RE: SSD-10391 New Liverpool Public School at 18 Forbes Street, Liverpool

Thank you for notifying Sydney Water of SSD-10391 at 18 Forbes Street, Liverpool, which proposes the construction and operation of a new primary school for 1,280 students. Sydney Water has reviewed the application based on the information supplied and provides the following comments to assist in planning the servicing needs of the proposed development.

**Figure 32 Existing location of the Sydney Water Sewer and Water Mains on the site**

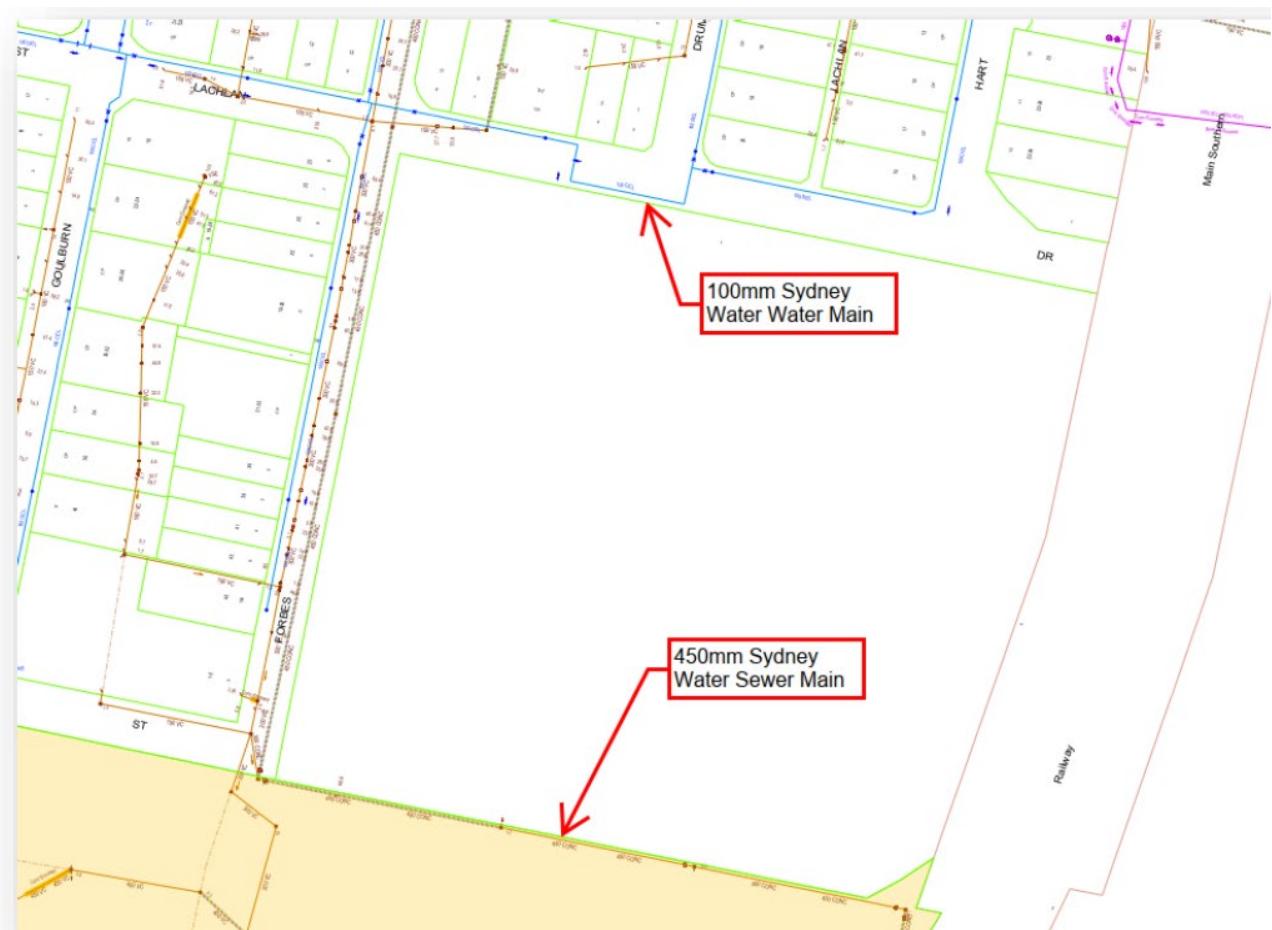
- Wastewater servicing should be available to the site.
- The Infrastructure Management Plan proposes a connection to the Sydney Water 450mm CONC wastewater main (laid in 1957) located near the southern boundary of the school. Detailed requirements regarding the connection to the 450mm main will need to be reviewed at the Section 73 application phase.
- Amplifications, adjustments, and/or minor extensions may be required.
